LSC Responses to Deviation No 1 Comments

A deviation from the standards of or in Sections 2.2.5.D. **2.3.2 and 2.3.7.B,C. Collector Access Standards** of the Engineering Criteria Manual (ECM) is requested.

Deviation No. 1 - Exhibit 1

Monument Ridge East (LSC# S234450)

Figure 3  
Proposed Realignment  
of Monument Hill Rd  
and Extension of  
Misty Acres Blvd

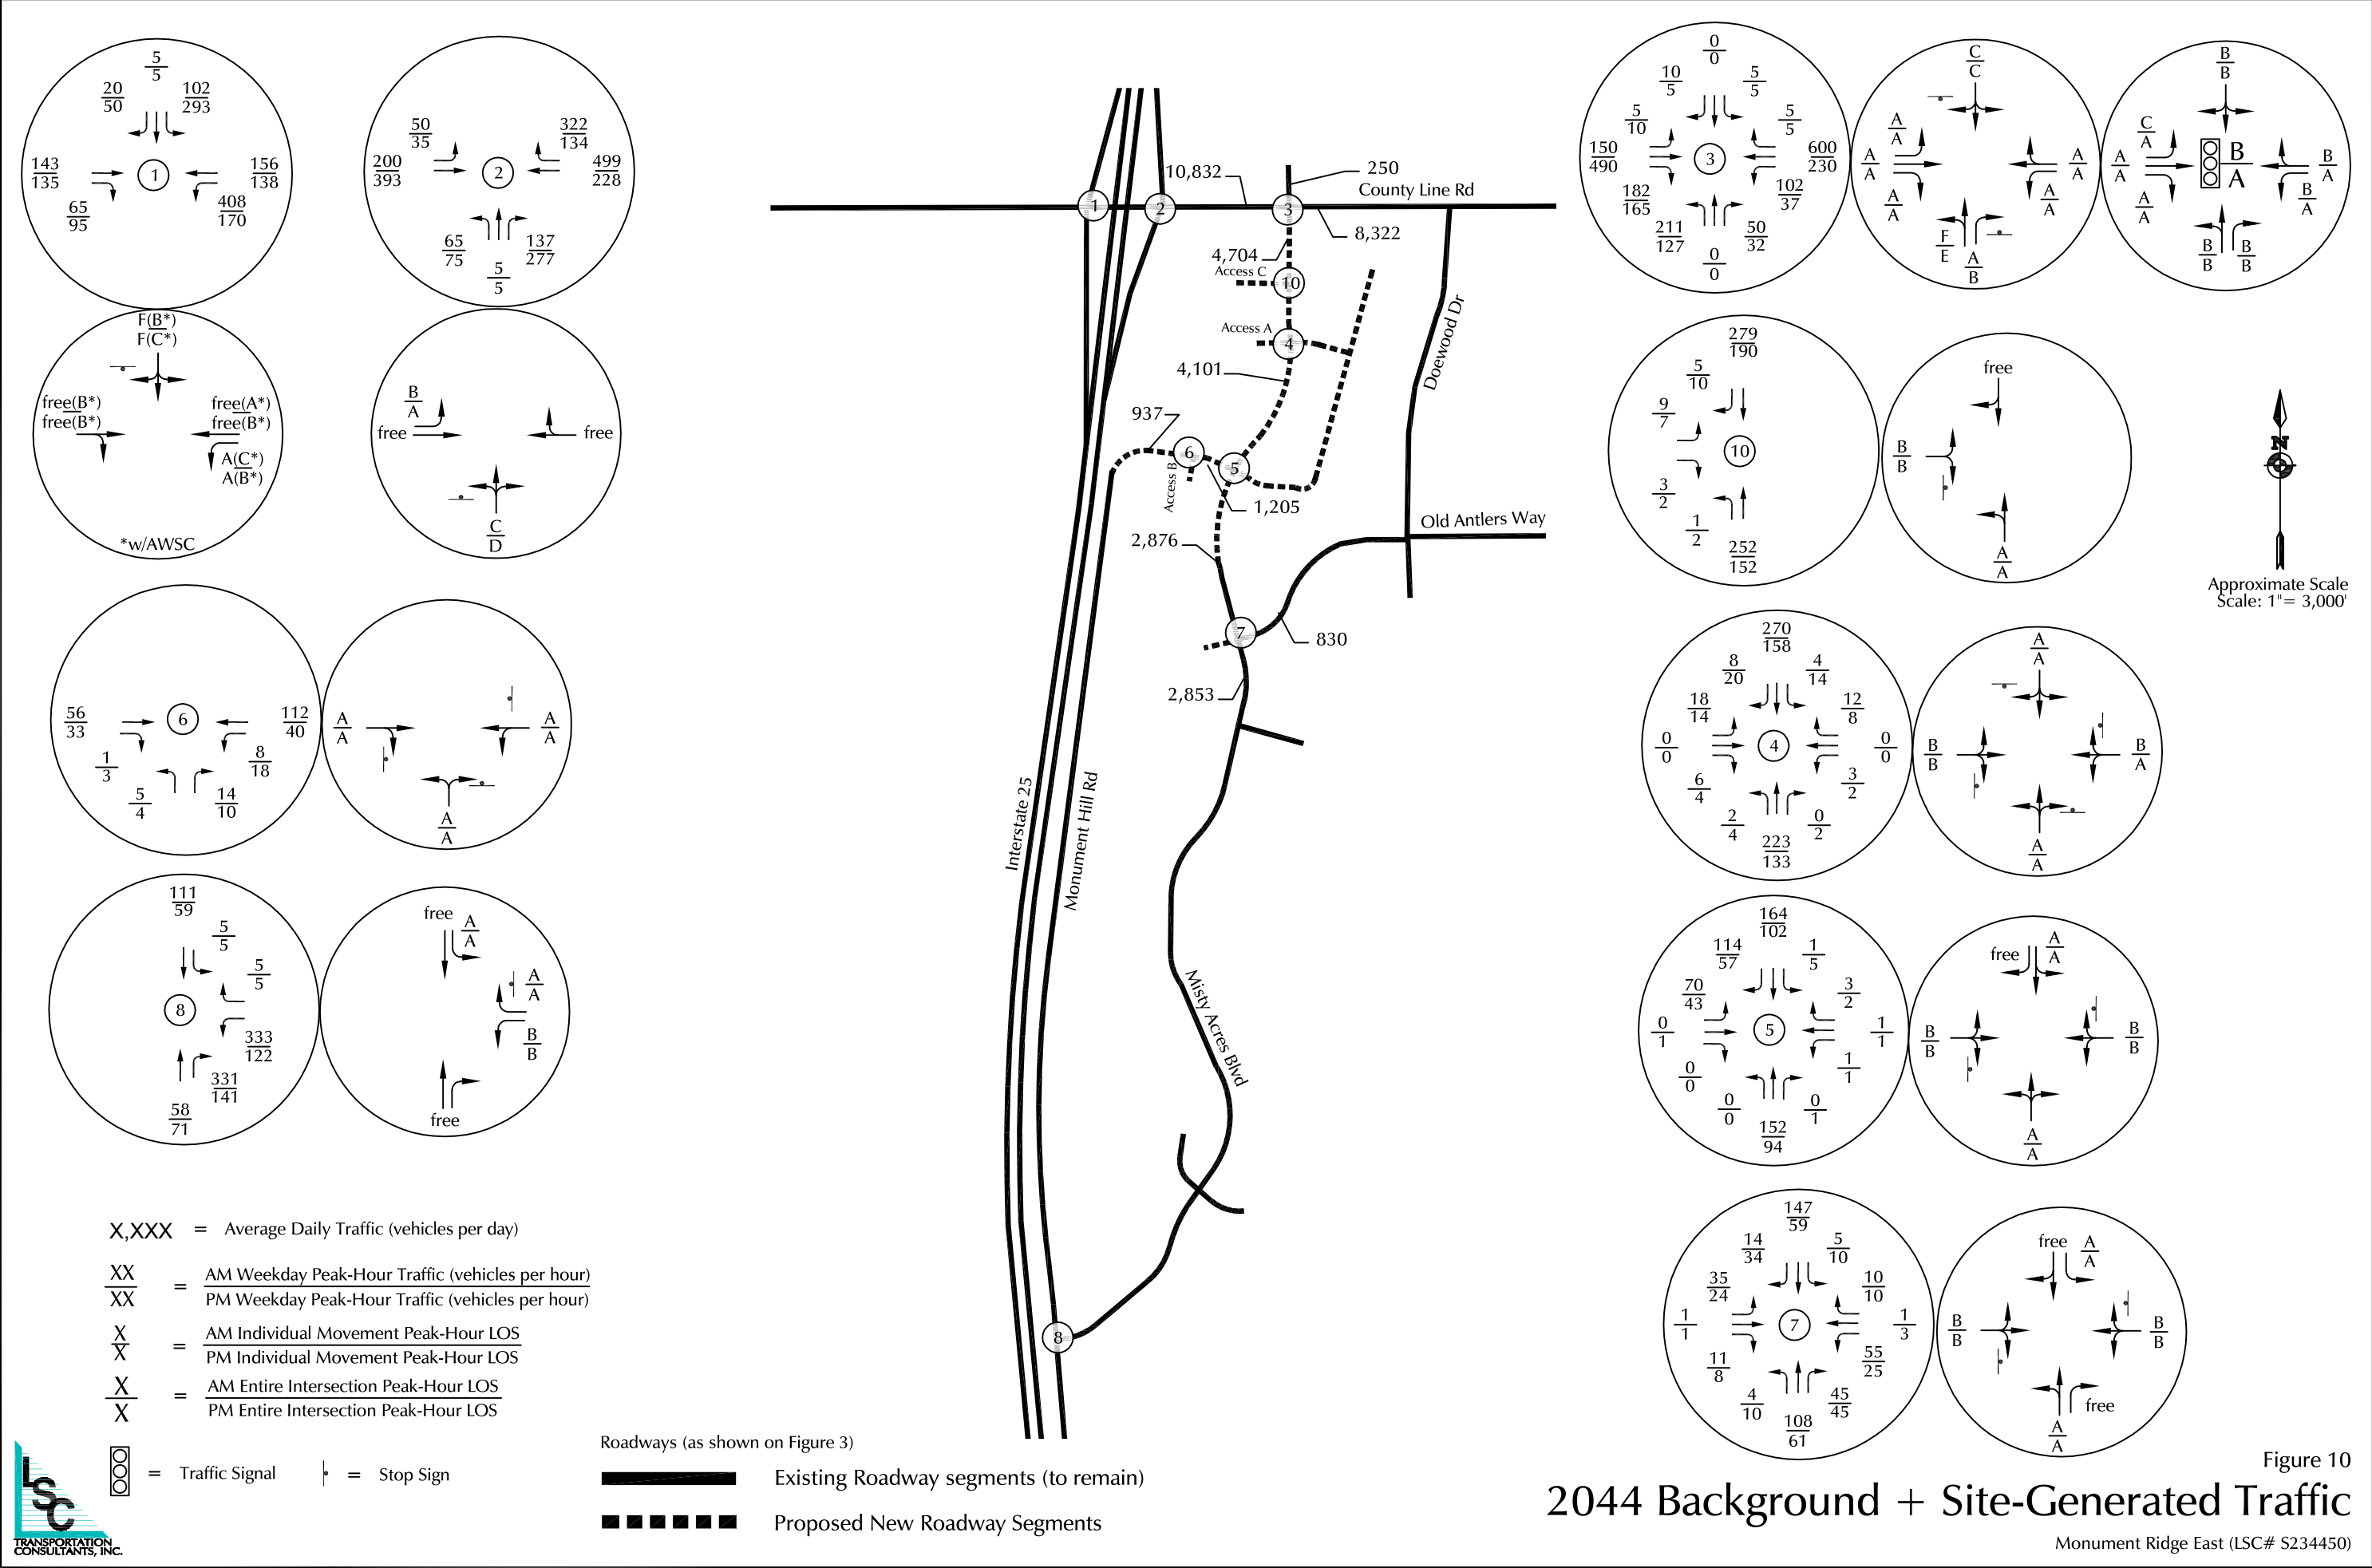
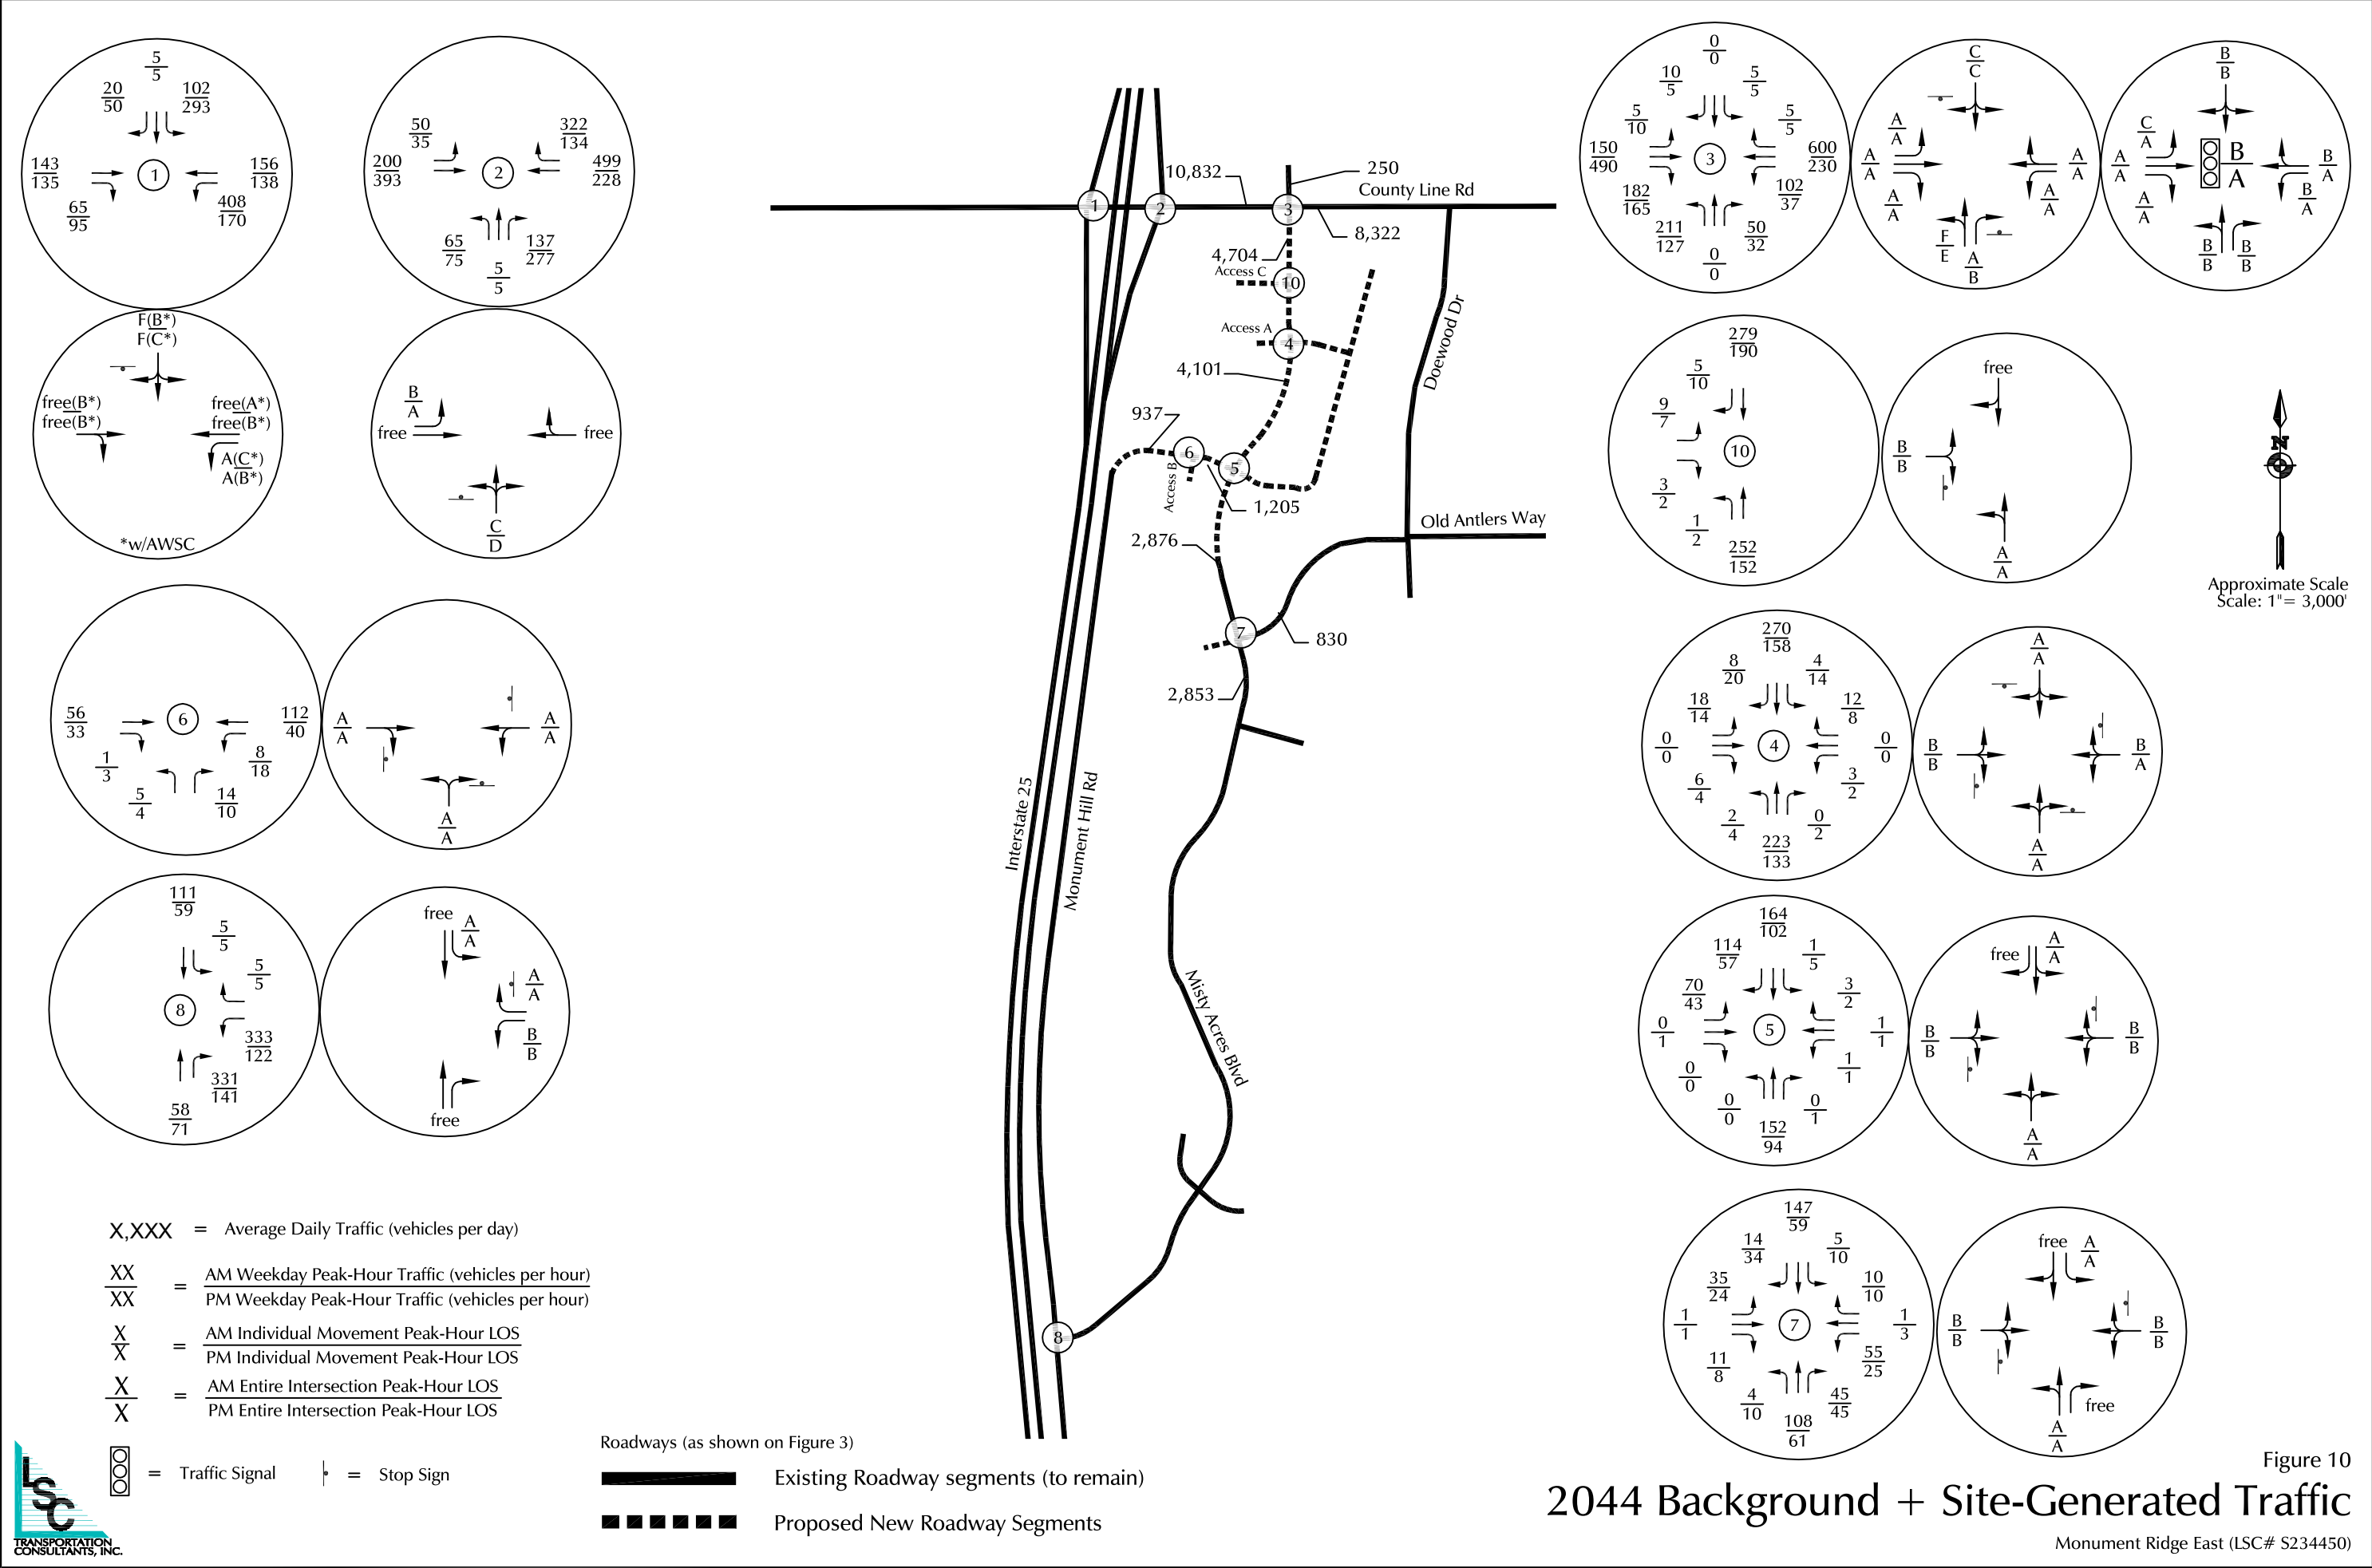
Please add the sight distance figure from the TIS as an exhibit

LSC Response: Added as Requested.
